Interested Party: [REDACTED] (David Burns)

In my previous submission I have highlighted that the course of pylons through north Colchester as well as the choice of location for the Western Sealing End Compound at Little Horkesley (Great Horkesley CSE - Tilbury Side in National Grids terminology but actually located in Little Horkesley) is far too close to the Dedham Vale and will cause great harm to it, as well as impacting on the setting of Grade II listed properties with historic uninterrupted views into the Dedham Vale, including but not limited to views into the Vale from my own 14/15th century Grade II listed farmhouse.

Zone of Theoretical Visibility (ZTV) - Dedham Vale National Landscape

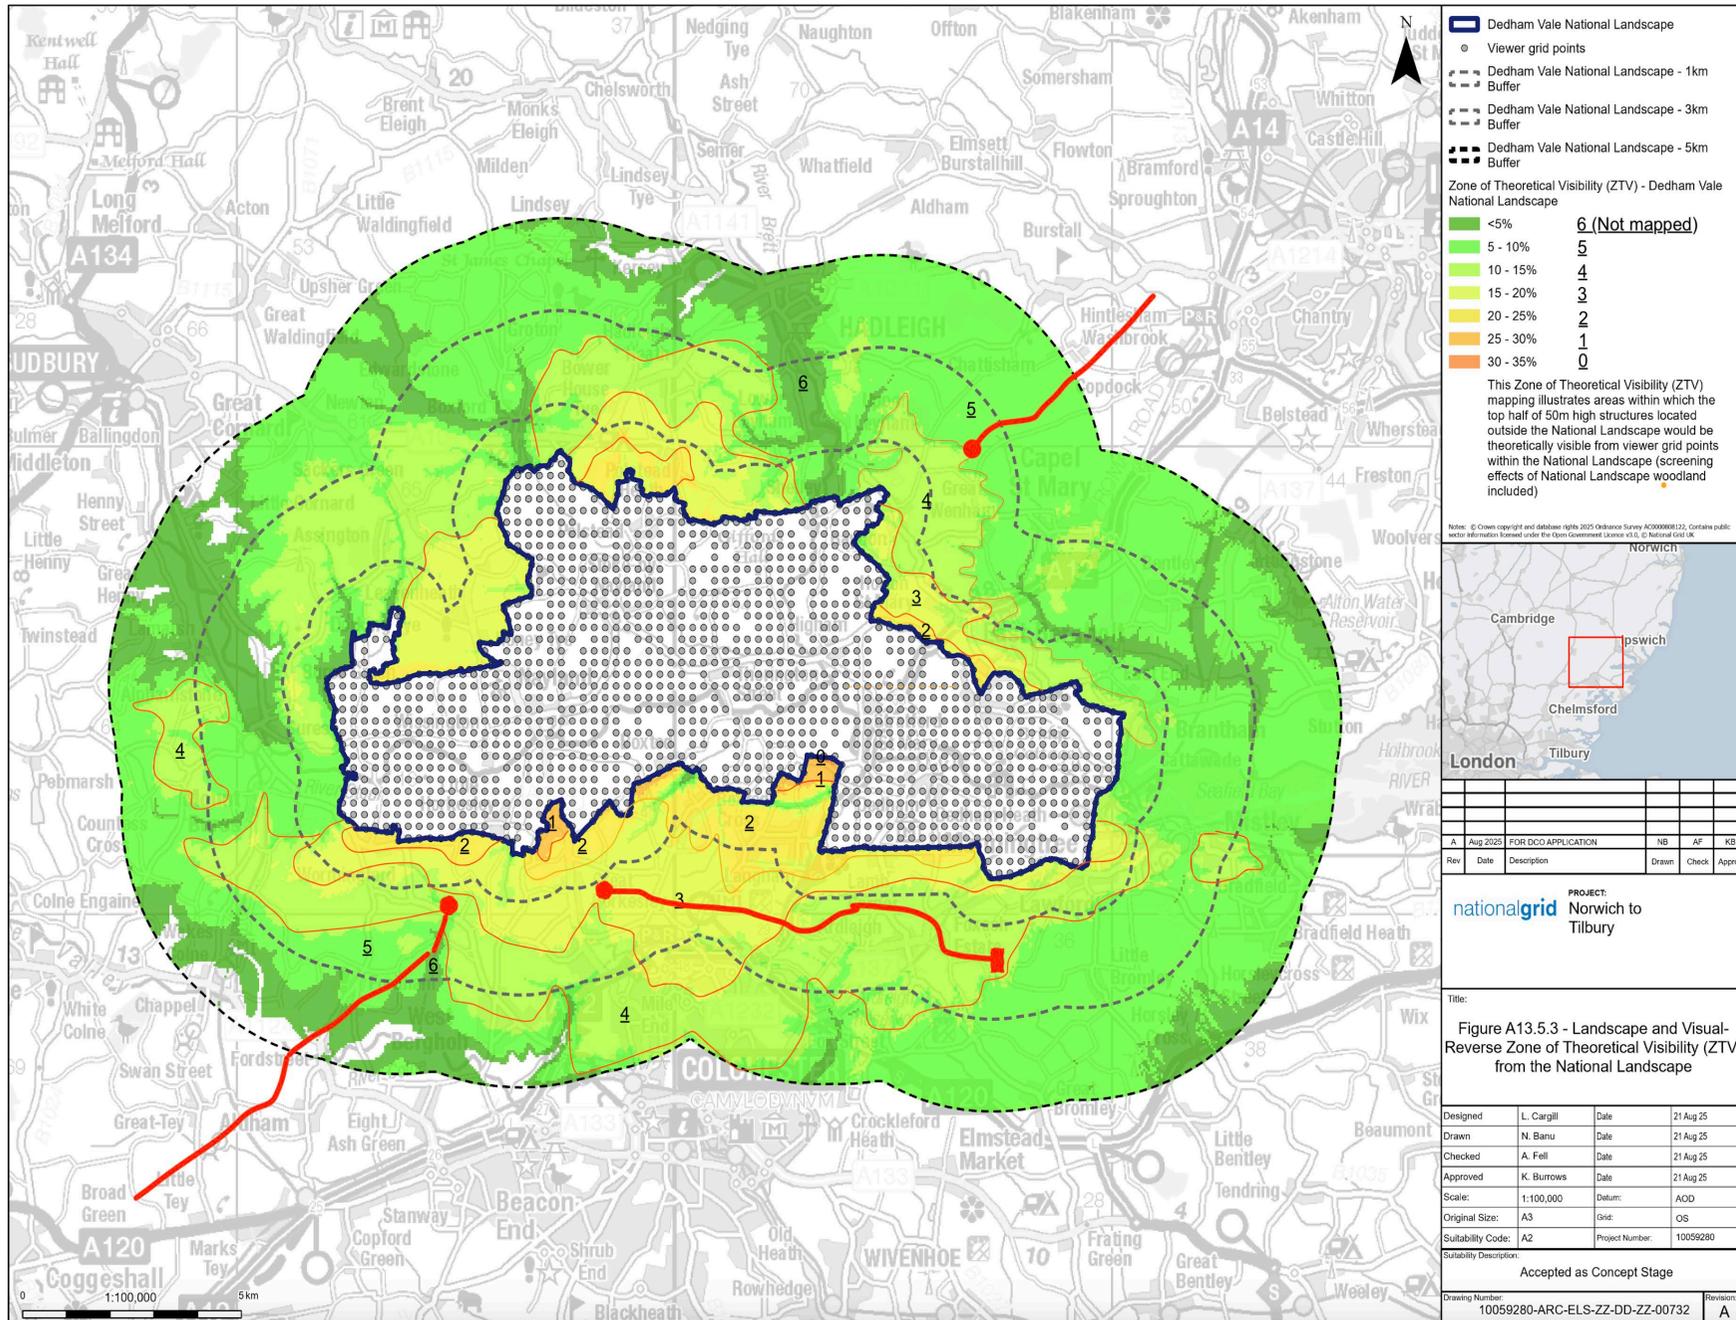
In their new document pack National Grid have provided figure A13.5.3 which illustrates the 'Reverse Zone of Theoretical Visibility'.

This diagram very much reinforces our point but is barely mentioned in the text: the route selected for pylons emergent from Ardleigh and the location of the Western CSE in particular are extremely poor. The EACN is in a location where it will be visible over between 20% and 25% of the Dedham Vale, as are many of the pylons. All fall within the 10-15% category.

It must be remembered that these are **individual** point wise measurements, being a reverse view fall map and that, as a result, the full impact arising within the Vale from the presence of all of the pylons in the South will be **dramatically higher** than suggested.

Had the Western CSE at Little Horkesley (red circle in lower left of diagram) been moved only 500m (per National Grid, the additional underground distance is less than the absolute distance between the two sites as the underground route going in would be altered slightly) to the south near to their alternatively proposed site near to TB42 (pink circle at bottom of diagram) it would have fallen into a valley from which it would have been visible over less than 5% of the Dedham Vale and from which it would not have interrupted any views from **any** historic buildings into the Vale. Subsequent pylons would also have similarly far less visible.

Interestingly, to the North of the Dedham Vale the site of the relevant Sealing End Compound there has been moved by National Grid even further North on the argument that visibility within the Vale needed to be reduced (Blue circle at top of diagram). The original choice of site was already **far less impactful** on the Dedham Vale than the one they are now defending at TB35/36 in Little Horkesley and they have reached the conclusion that it needed to be further away.

The planning inspectorate MUST require AT THE VERY LEAST a change from TB35/36 to TB42 or beyond.
